Application by DS Smith Paper Limited for The Kemsley Mill K4 Combined Heat and Power Generating Station

The Examining Authority's Second Written Questions and Requests for Information (ExQ2)

Issued on 22 October 2018

Status Information  
 Drawn By HK PM/Checked By NB  
 Job Ref ECO00047 Scale @ A3 1:80,000 Date Created 07.2018  
 Figure Number 10.1d Rev

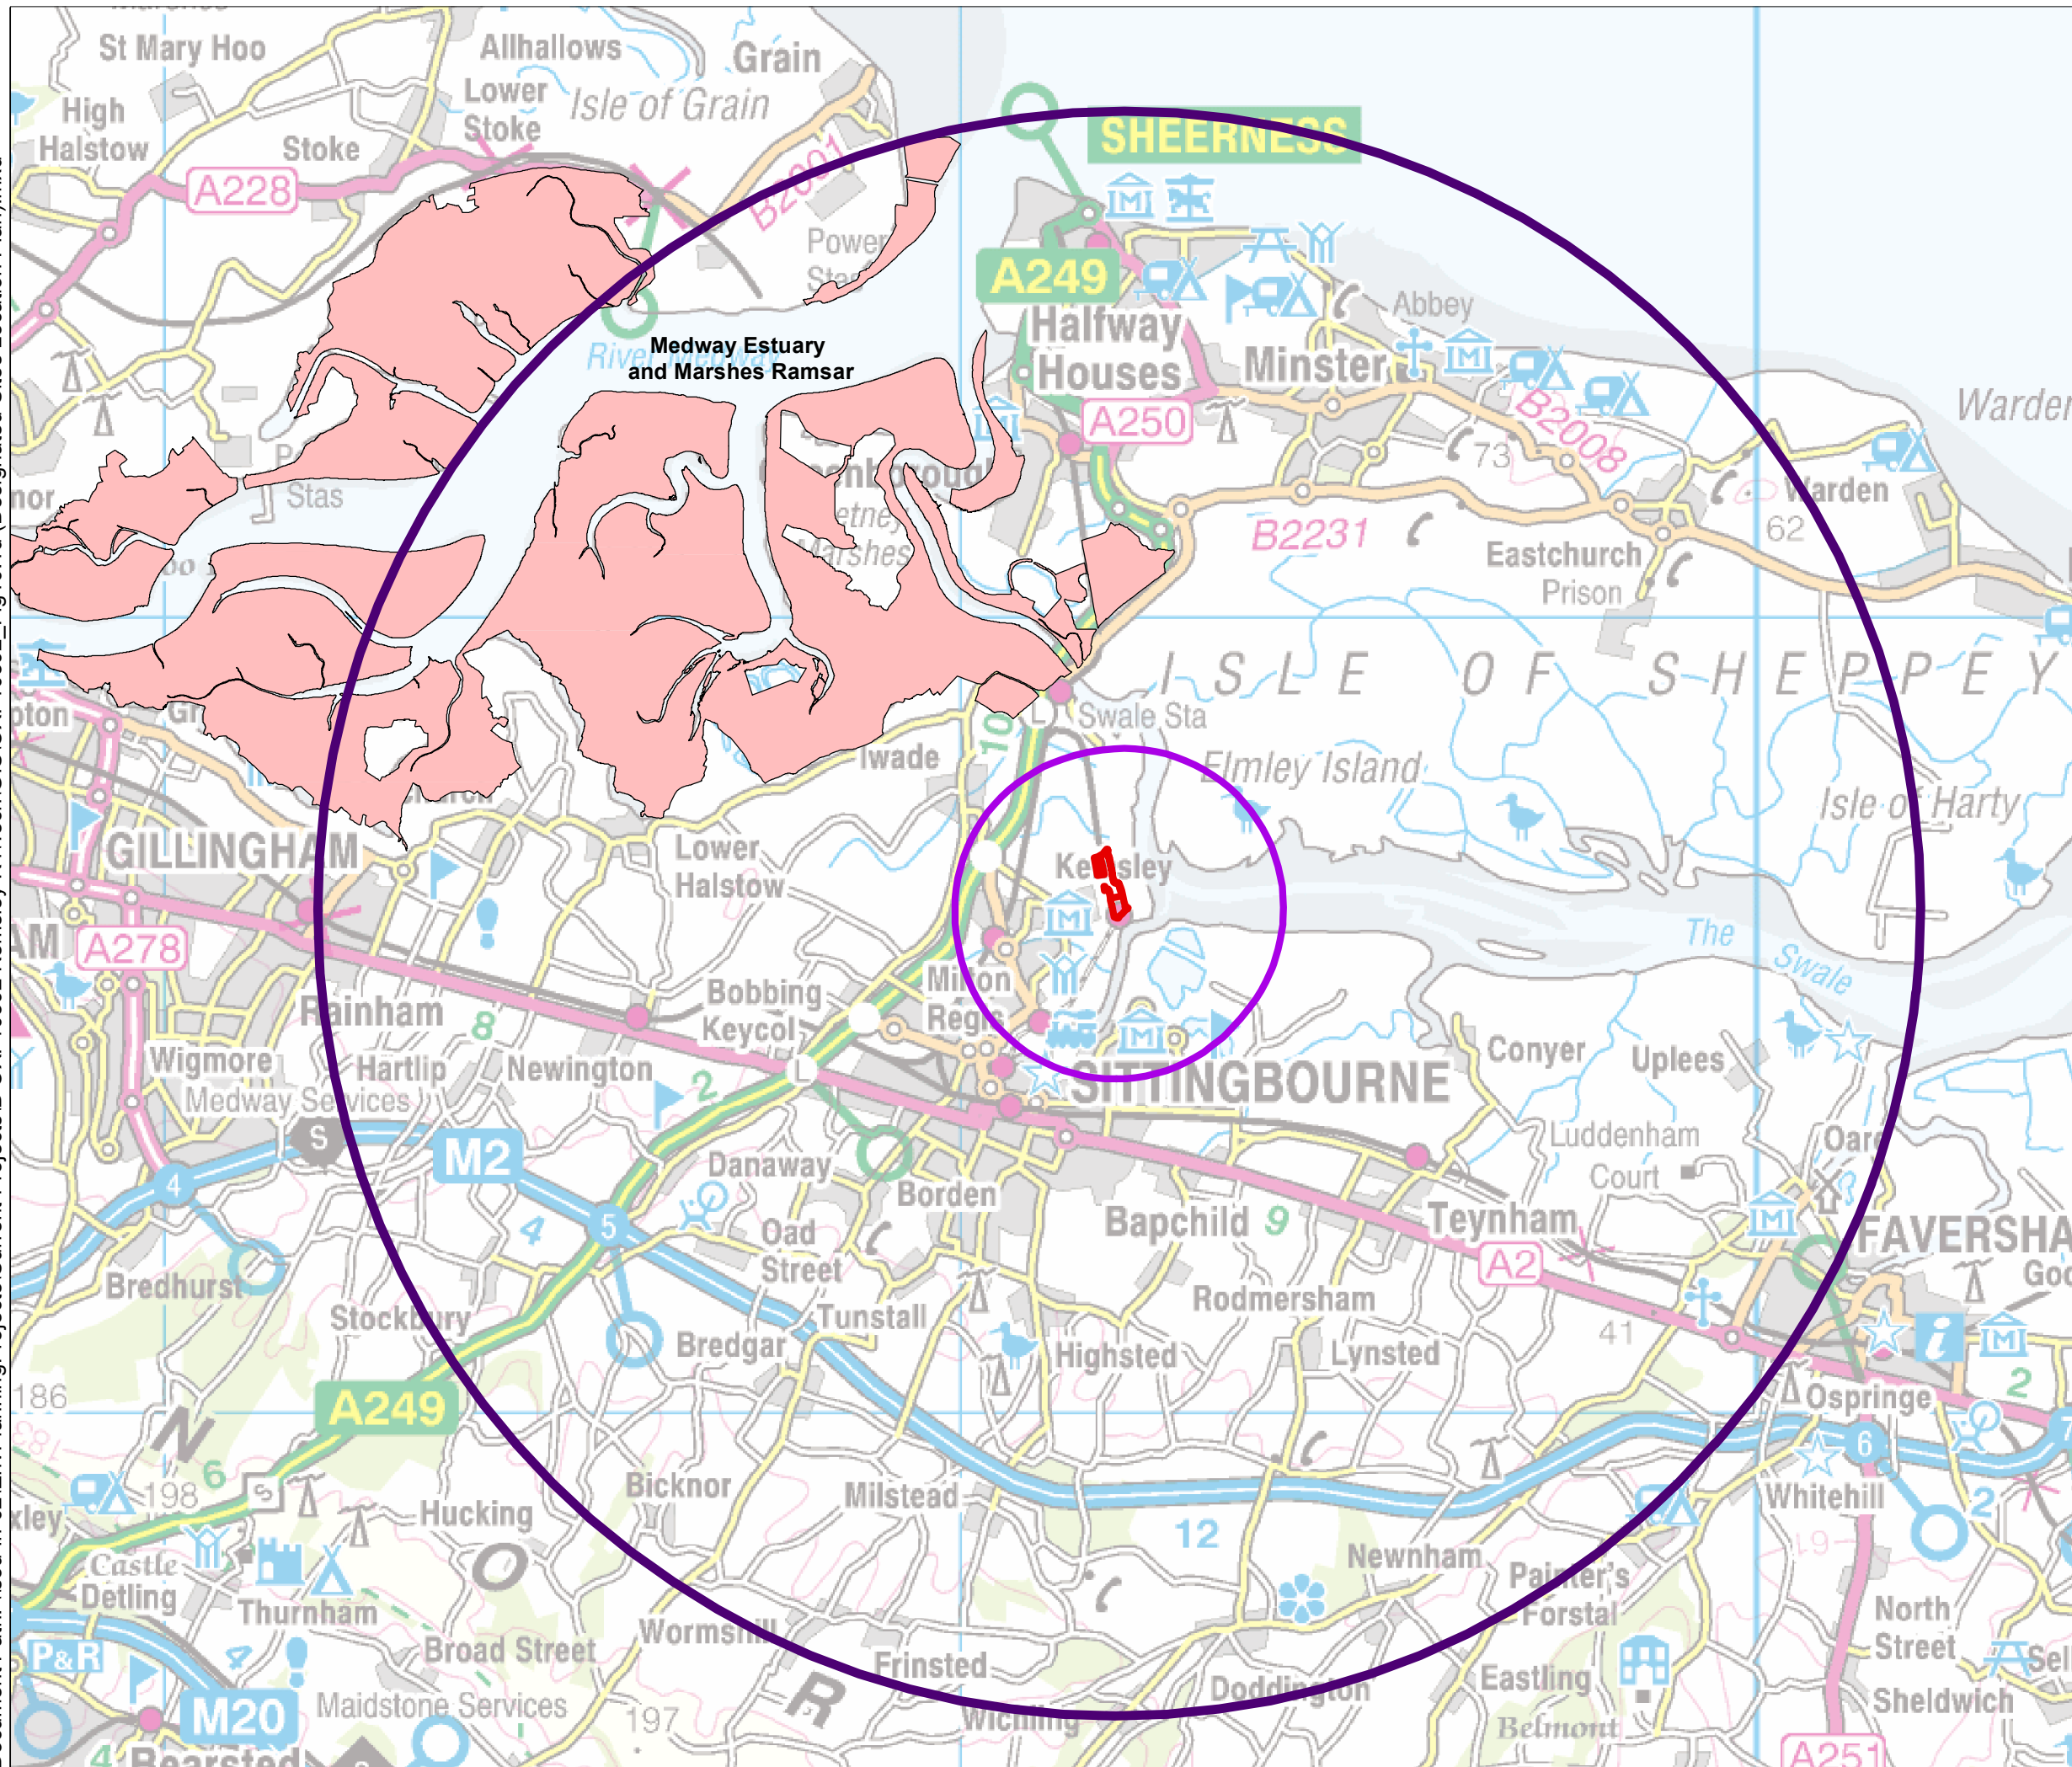
Q2.4.1	IPs	<p>A revised Habitats Regulations Assessment Report (HRAR) was submitted by the Applicant as a Post Deadline 4 Version [AS-022].</p> <p>All IPs are asked for their comments on the findings of the revised HRAR.</p>
Q2.4.2	Applicant	<p>Figure 1 of the revised HRAR [AS-022] (although not referenced as such) on Page 6-10 outlines four stages of HRA. Subsequent text from paragraph 3.3 -3.13 does not follow the stages identified in Table 1 and Stage 4 from the previous version of the HRAR [APP-033] has been deleted.</p> <p>The Applicant is asked to clarify the structure of Section 3 of the HRAR.</p>
Q2.4.3	Applicant	Table 4.4 of the revised HRAR [AS-022] has deleted the section headed ' <i>Regularly supporting more than 1% of the GB breeding population of an Annex 1 species in summer</i> ' which occurred in the previous version [AS-002]
